**ANGEL PLACE
LEVEL 8, 123 PITT STREET
SYDNEY NSW 2000**

RESPONSE TO REQUEST FOR FURTHER INFORMATION - SSD-9368-MOD-2 - GALUNGARA PUBLIC SCHOOL (ALEX AVENUE)

This letter has been prepared to respond to the Department of Planning, Industry & Environment (DPIE) request for further information (RFI) letter dated 6 October 2020 in relation to the assessment of SSD-9368-Mod-2.

Drawing Title
ADDITIONAL SECTIONS

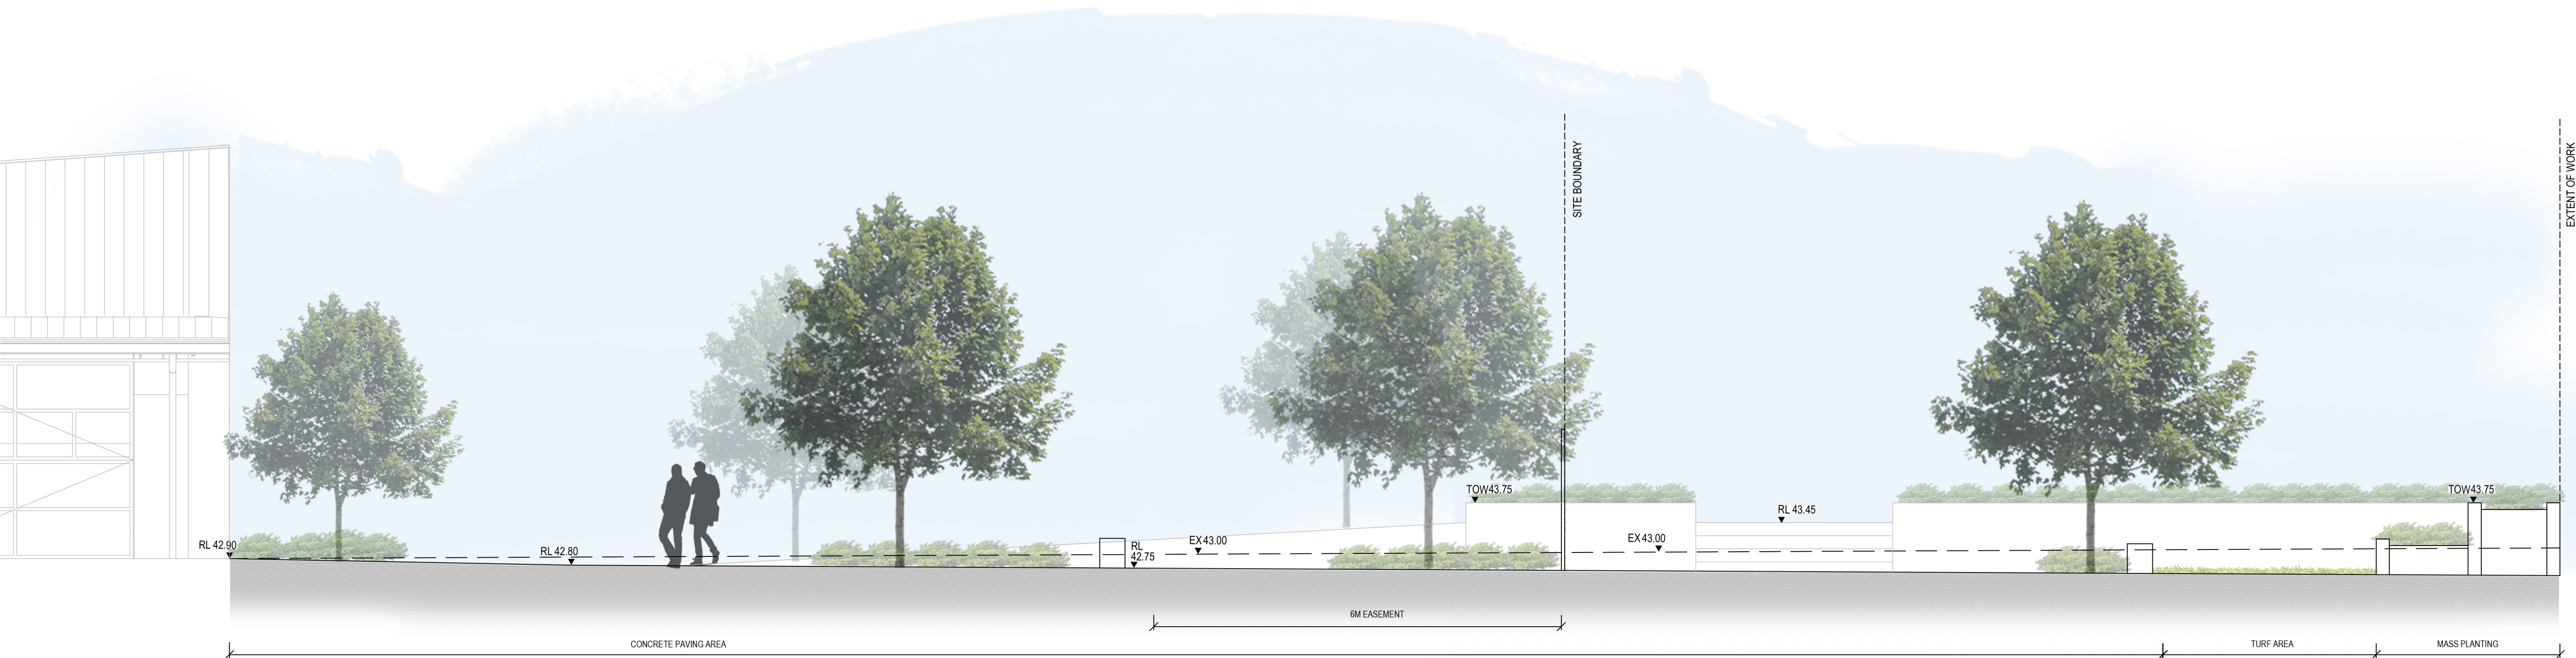
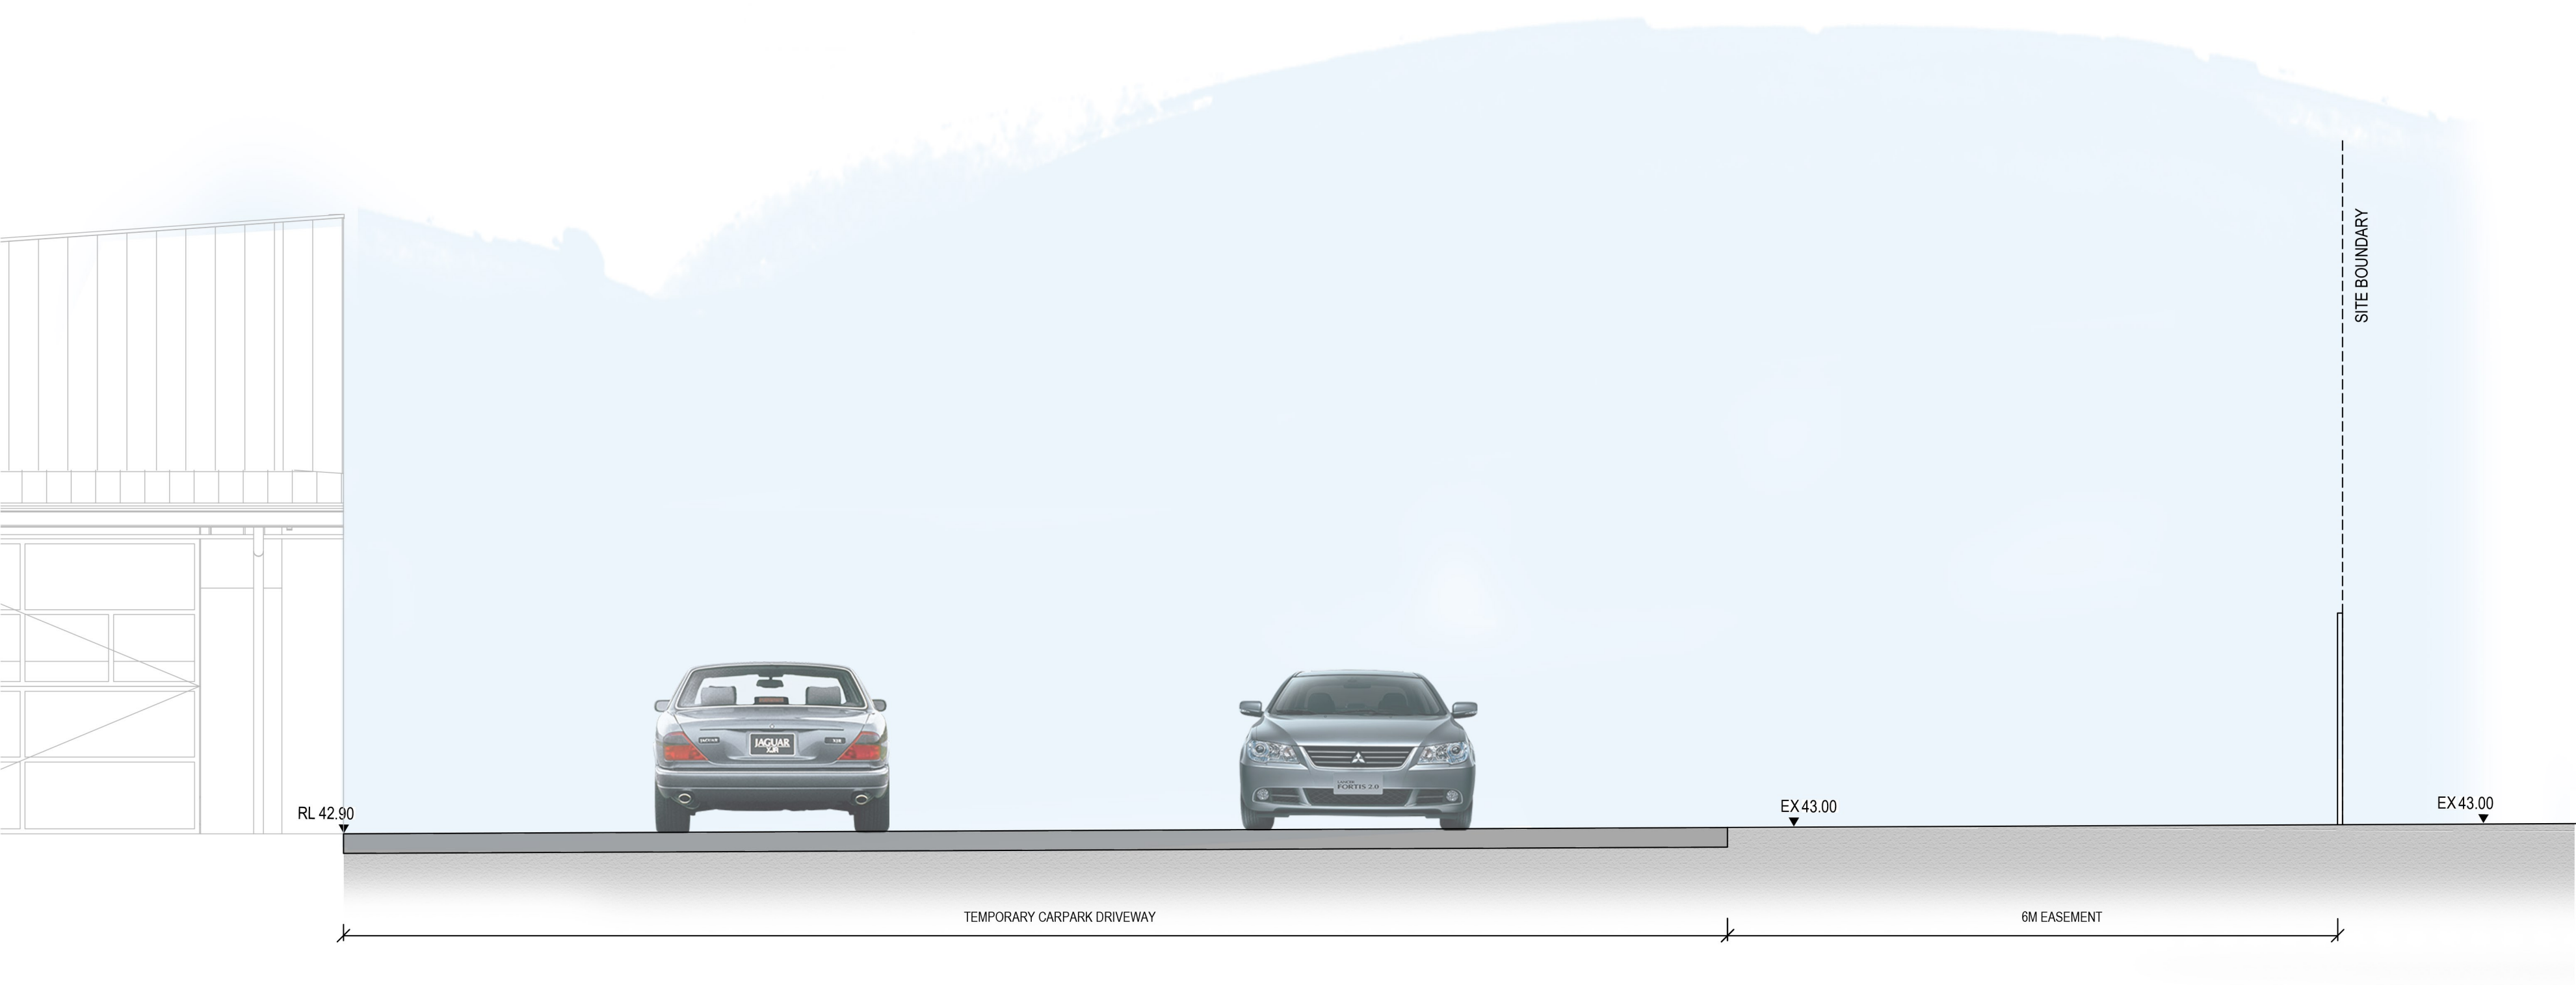
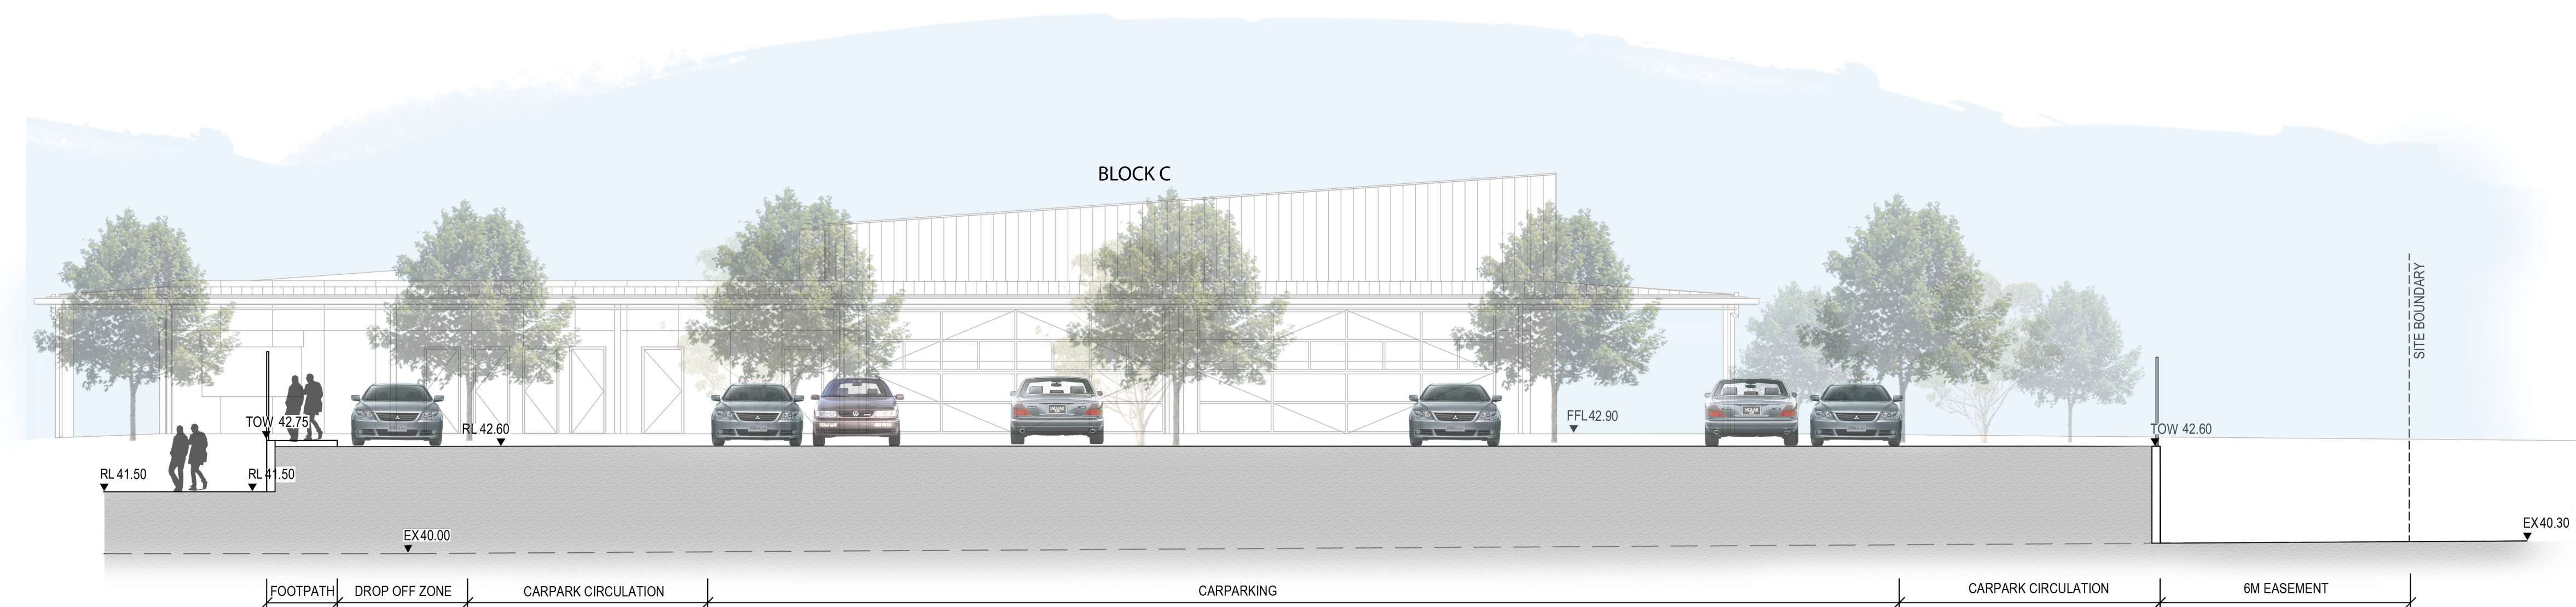
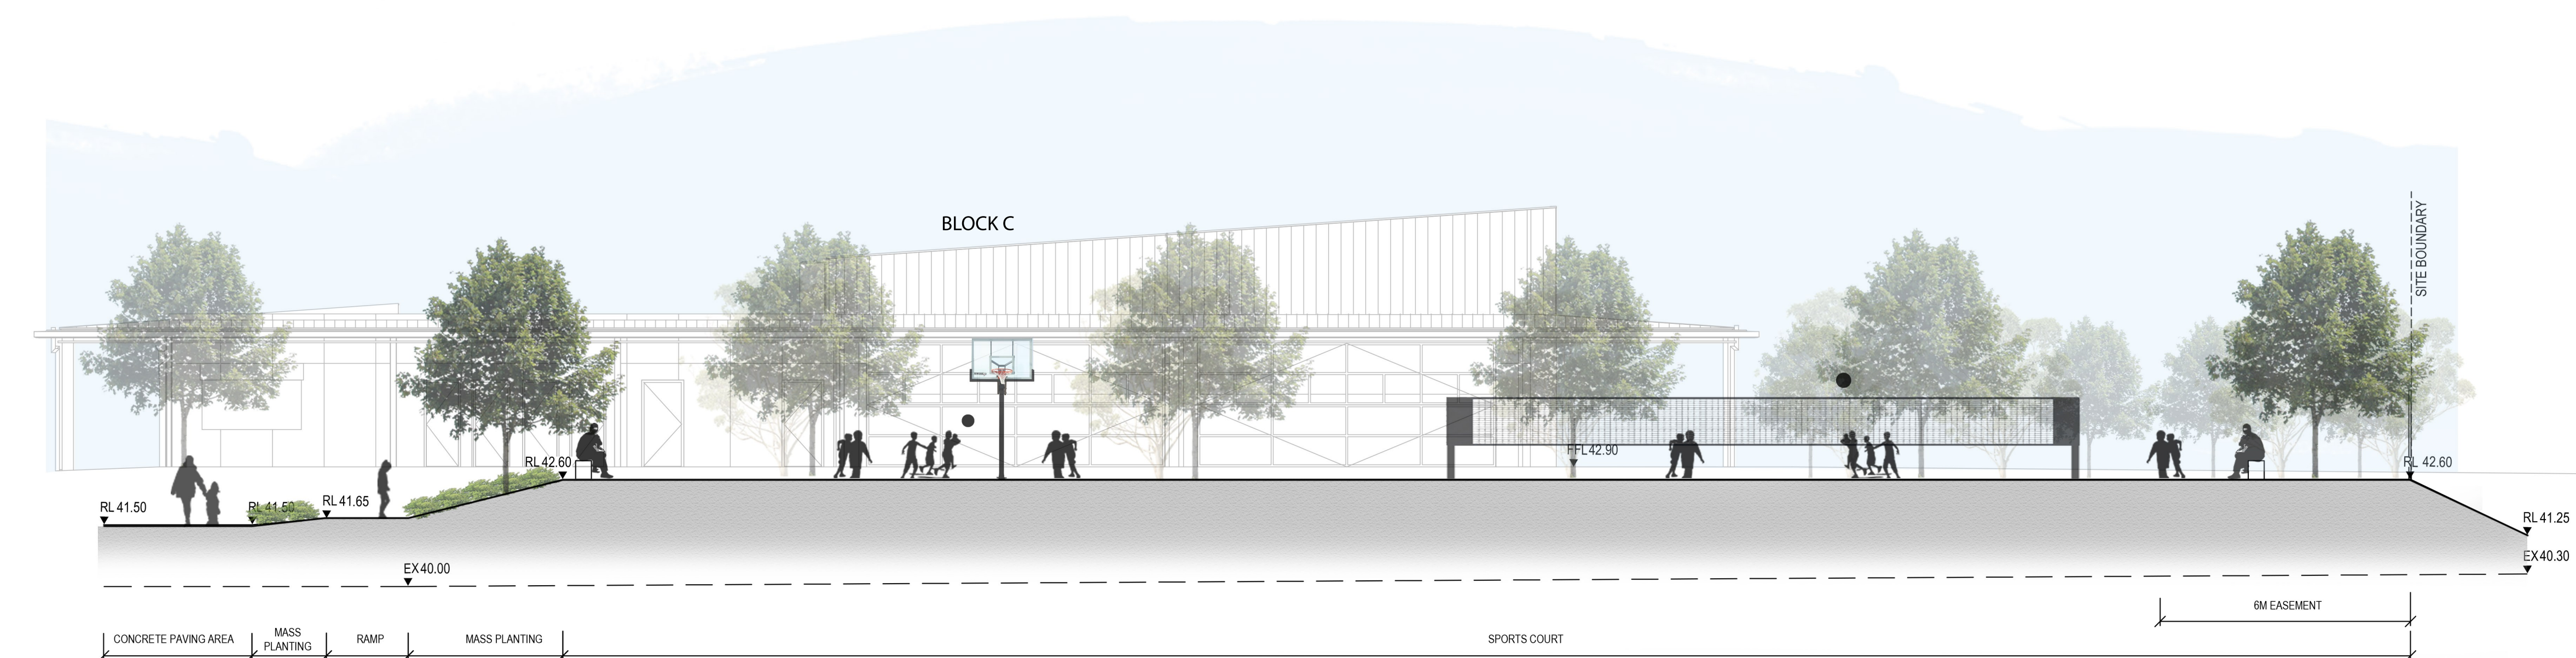
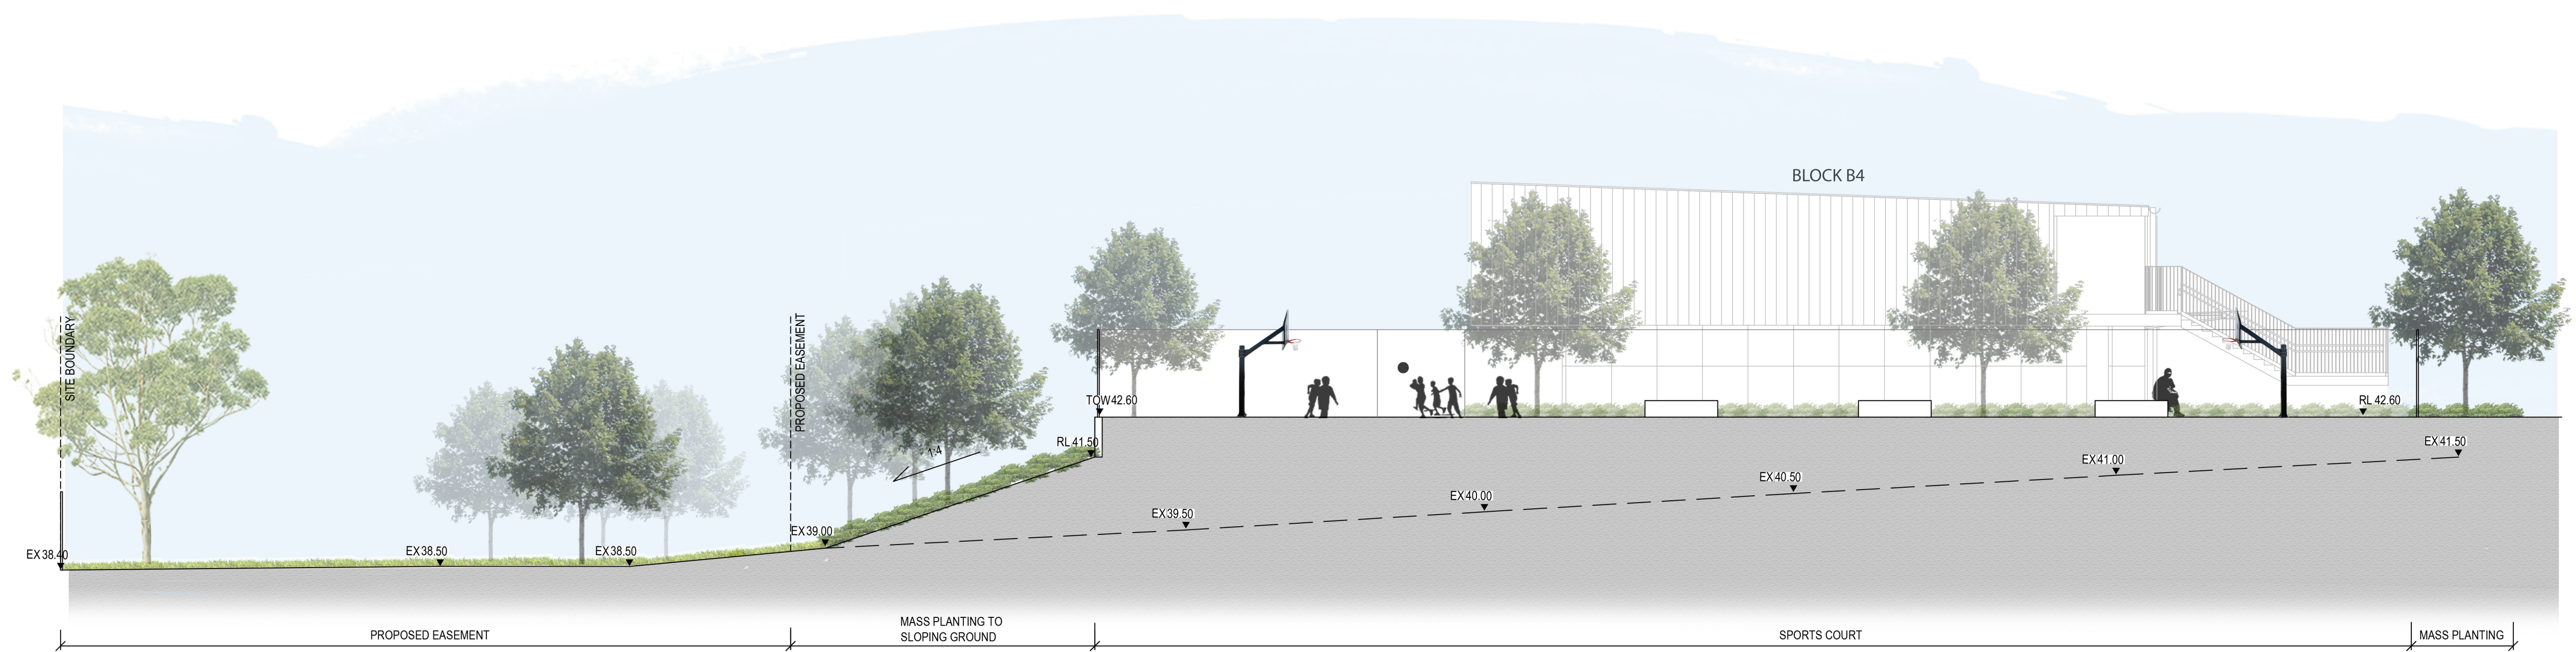
Sections and levels	It is not clear from the amended landscape drawings whether any changes are proposed to approved levels at the site's southern boundary where it adjoins Lot 4 DP 1244925. For example, on the approved landscape drawing no. 180645 L-3001 (Issue F) the levels are shown on the drawing, however on the amended landscape drawing no. 180645 L-3001 (Issue H), the levels on the site have been omitted. If any changes are proposed to the approved levels, particularly at the interface of the	There are no changes proposed to the site levels along the southern boundary. Please find attached to this letter indicative landscape section drawings (included for reference and information) as previously included in the Supplementary RtS package of SSD-9368 to demonstrate the intent of both the temporary carpark and sports court arrangements. As these drawings are not referenced in the consent and are indicative only, they have not been updated for inclusion in the modification document register.	Appendix C

Issue	Comment	Project Team Response	Reference
	<p>subject site and Lot 4 DP 1244925, please clearly show this on the amended plans and provide additional section drawings of this interface.</p> <p>In addition, on the amended landscape plans drawing nos. 8065 L-2002 (Issue P) and L-2003 (Issue N), reference is made to sections noted as “1&2/9001”, “3&4/9002” and “05/9003”. However, these referenced sections could not be found in the amended landscape drawing package. Please provide these referenced section drawings.</p>		
<p>Fence and gate plan</p>	<p>On the amended fence and gate plan (drawing 180645, L2200, Issue M), a change is proposed to gate No. G25 as shown in the schedule. However, the corresponding gate (G25) is not shown on the amended plan. Please review and identify the location of gate G25 on the amended plan.</p>	<p>The fence and gate plan has been updated within the Amended Landscape Drawings to show the inclusion of G25 gate along the Farmland Drive frontage.</p>	<p>Appendix C</p>
